*23* October 2019

ATTENTION: DIRECTOR – KEY SITE ASSESSMENTS

State Significant Development Application Number SSD-10300.  
Coffs Harbour Cultural and Civic Space.

GORDON ST ELEVATION

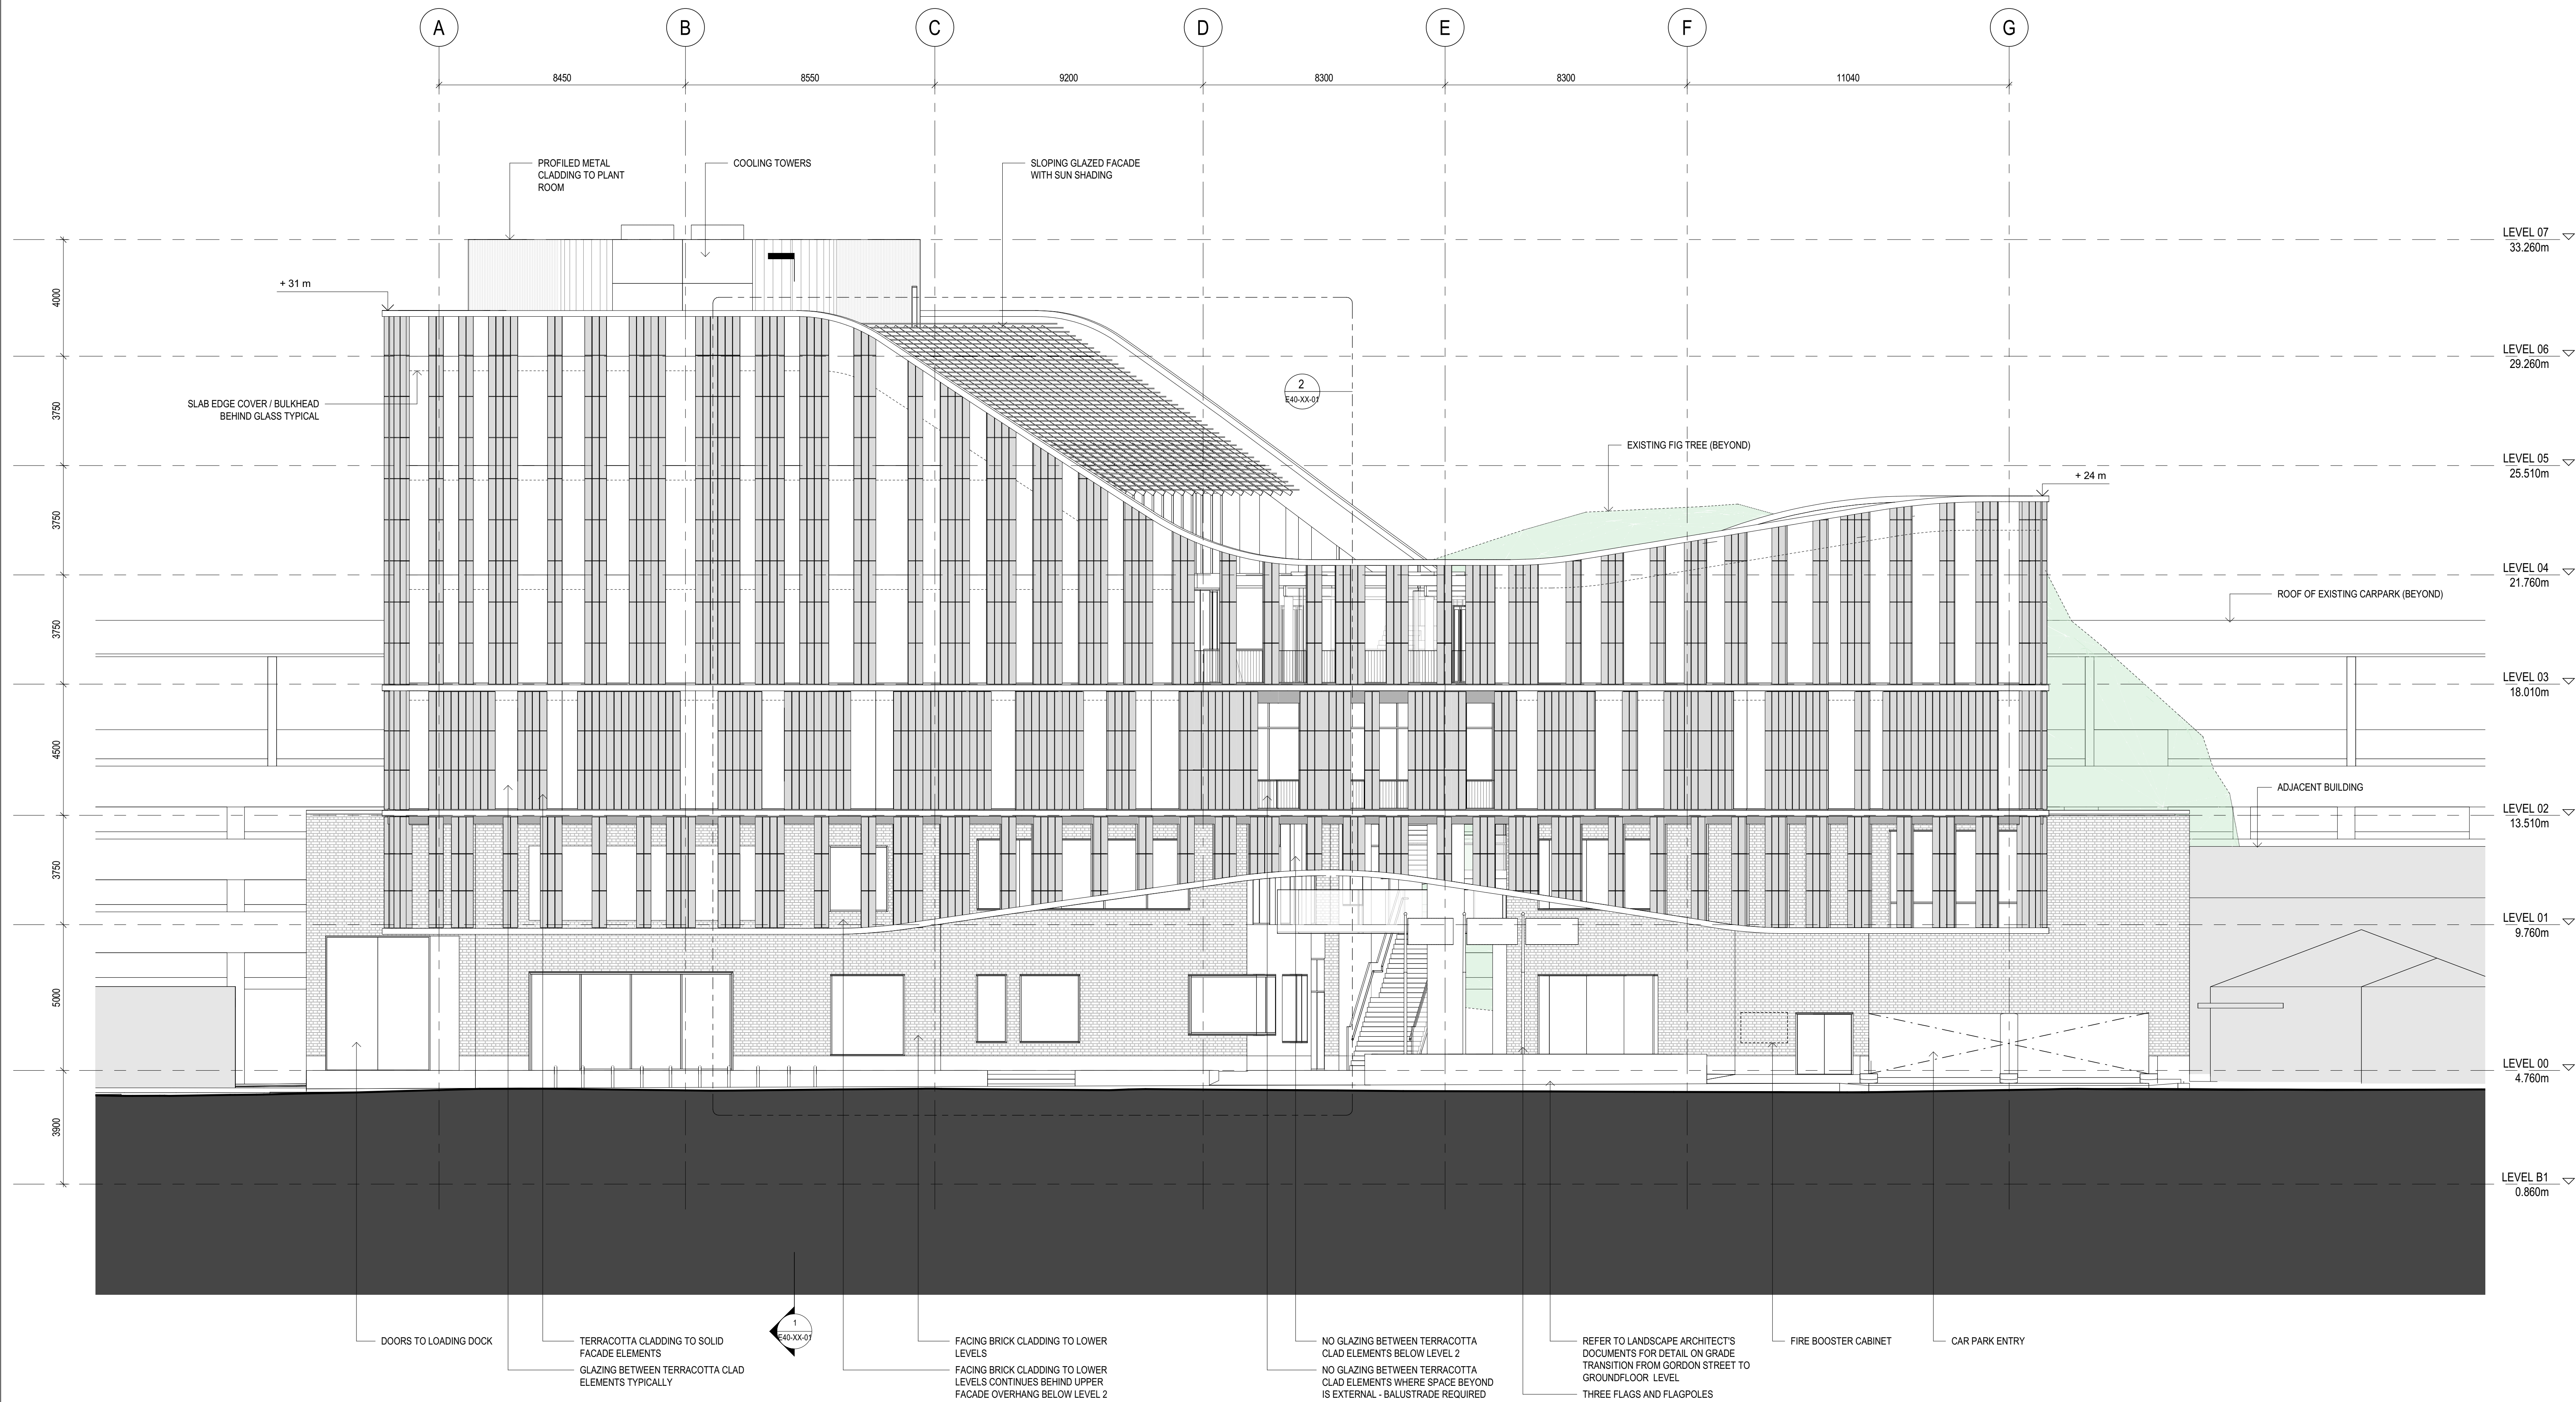
7. It conflicts with the streetscape in Gordon Street in that the proposed building is outside the context of this street having regard to the scale, existing street setbacks, design and general form of the adjoining buildings.
